Our Ref: DOC18/86954

Your Ref: SSD 5792

Re: Cairncross Waste Management Facility SSD 5792

Attachment 1: Detailed OEH Comments – Public Exhibition Cairncross Waste Management Facility SSD 5792

Figure 1-2 Site layout

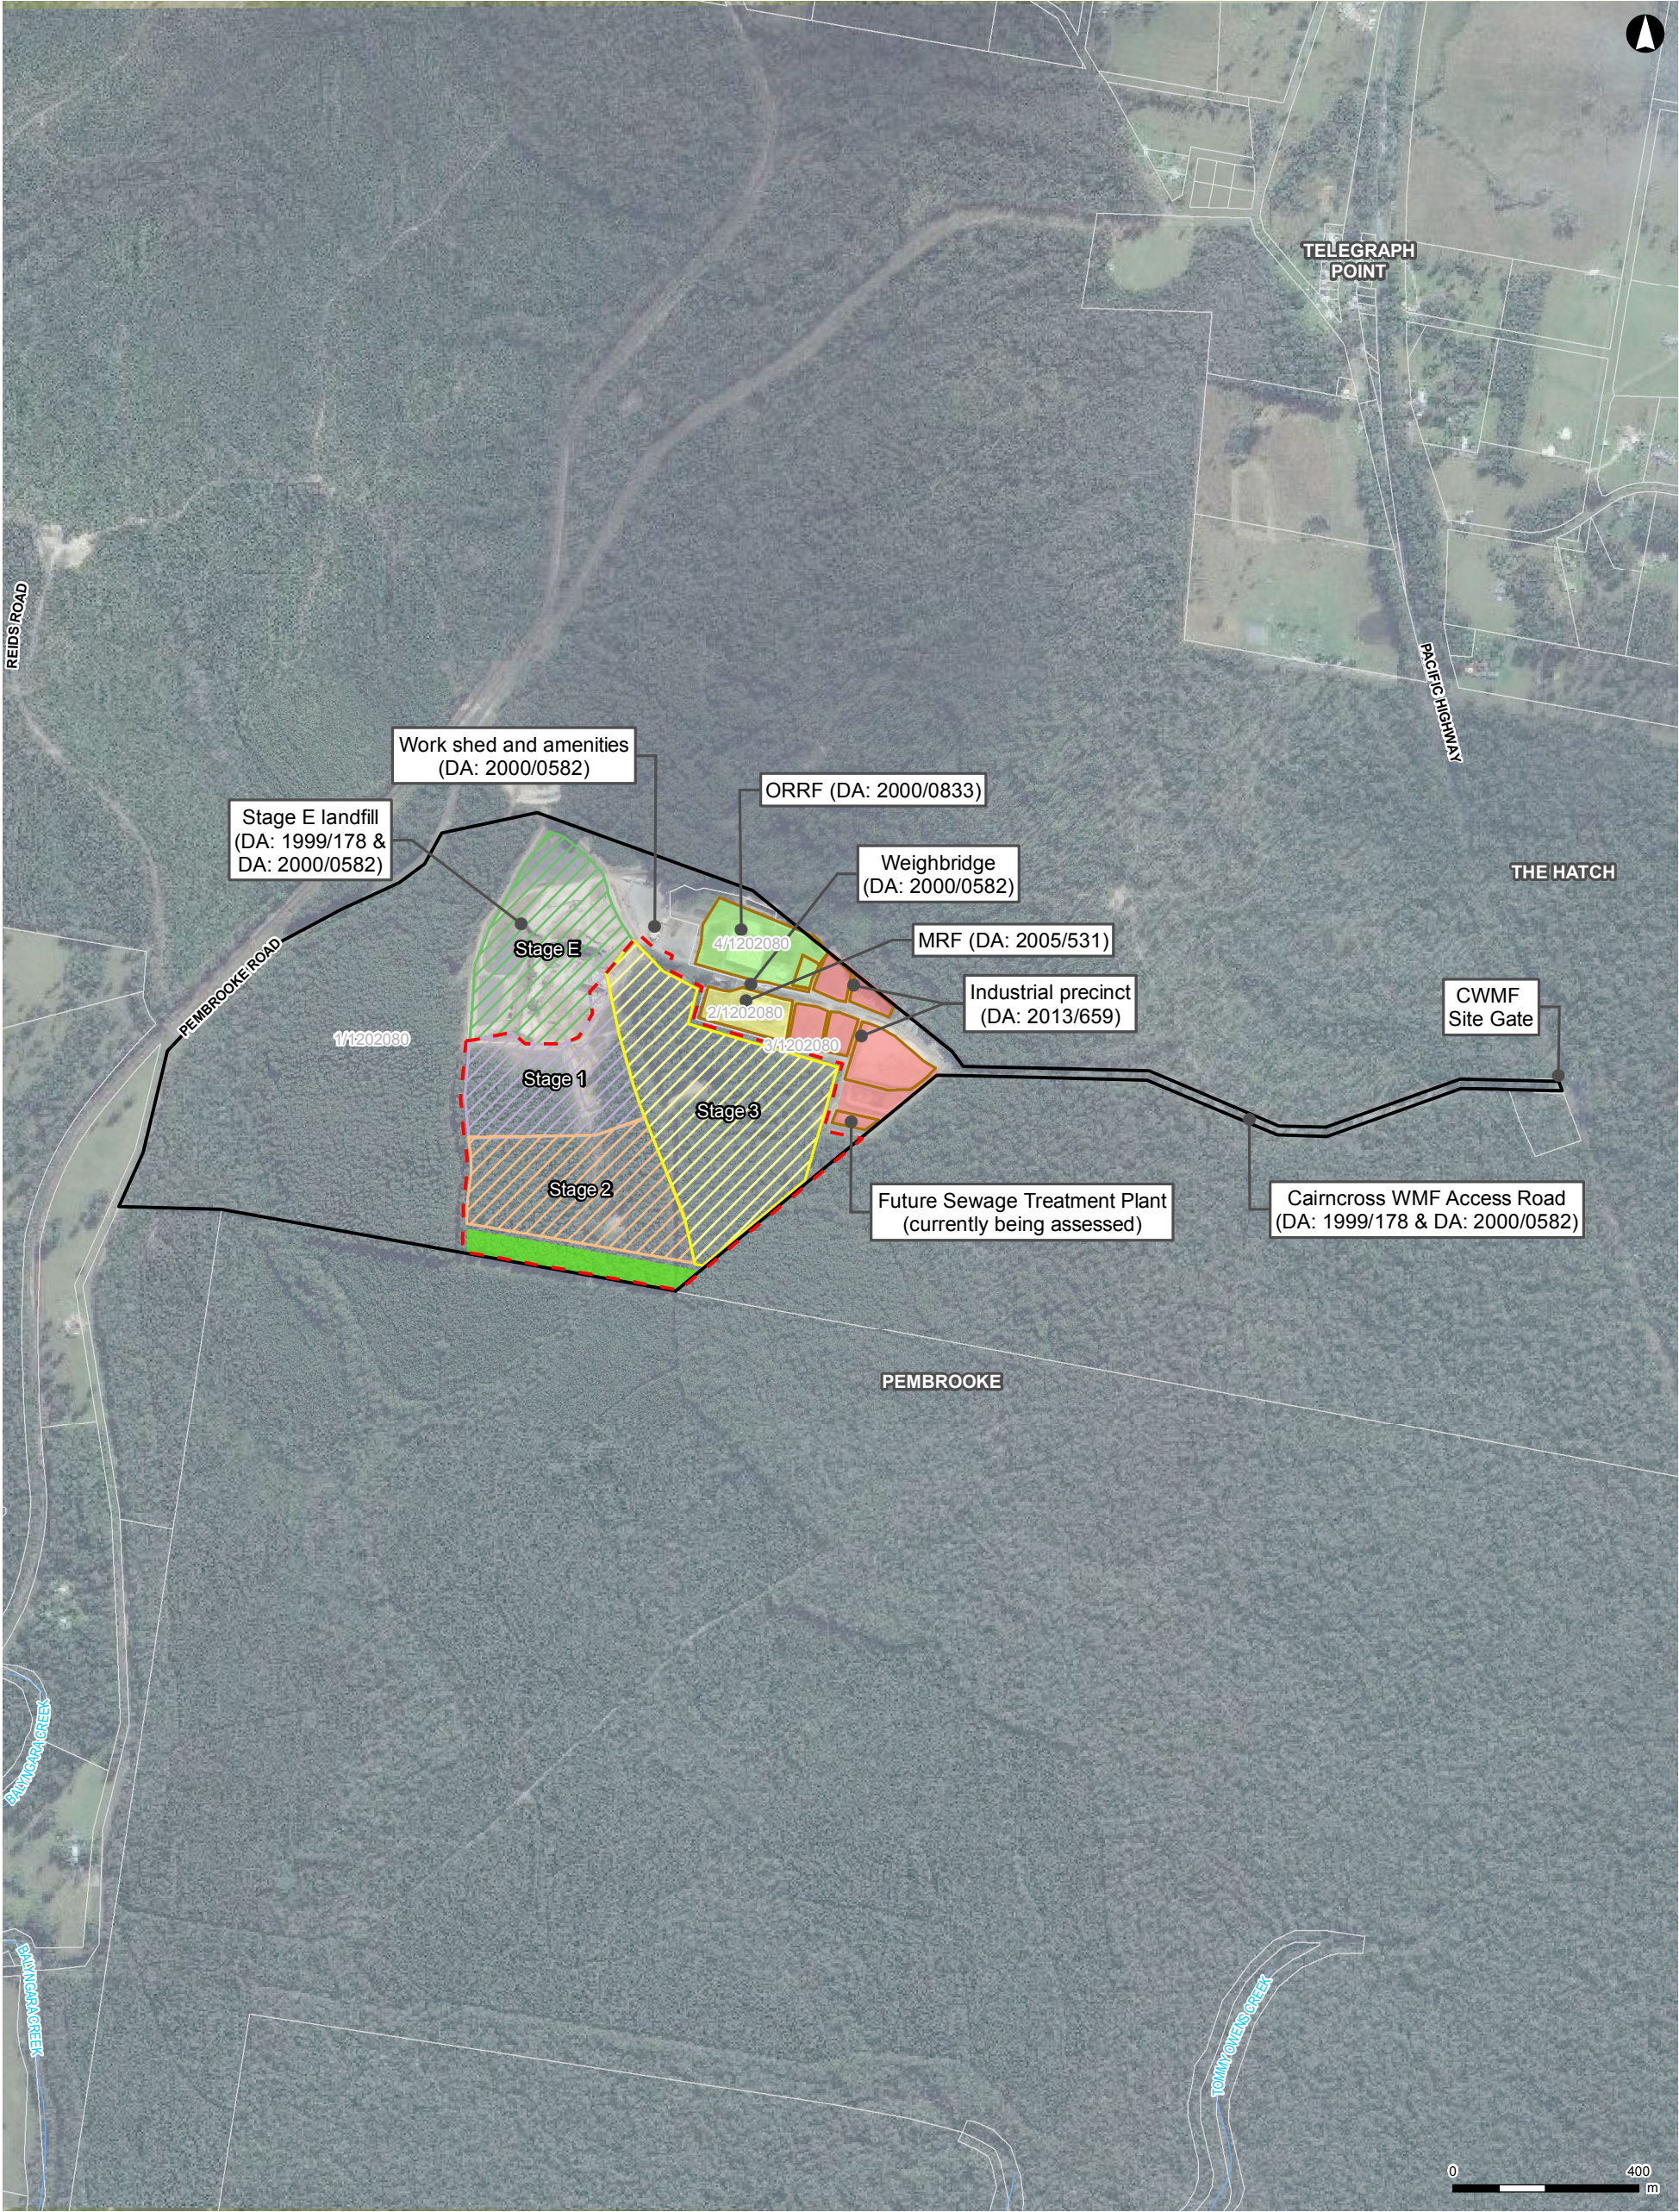
For the southern boundary, fencing and an all-weather fire trail access are proposed. This infrastructure should be located outside the area to be retained and managed as a koala connectivity corridor.

A koala connectivity corridor is proposed to be established to partially offset the impacts to koala habitat as identified in Figure 8-7 of the BAR. The corridor would be approximately 50m wide and would run along the southern boundary of the subject land. The BAR suggests the koala connectivity corridor will be managed to encourage use by native species, specifically koalas, as well as other species likely to be impacted by the Proposal including Green-thighed Frog and several threatened microbats.

- d) Fencing and fire trail access in the vicinity of the southern boundary of the subject land should be located outside the 50 m wide area to be retained and managed as a koala connectivity corridor.

7. A vegetation management plan (VMP) should be prepared and implemented for the 50m wide koala connectivity corridor. This should include the following:
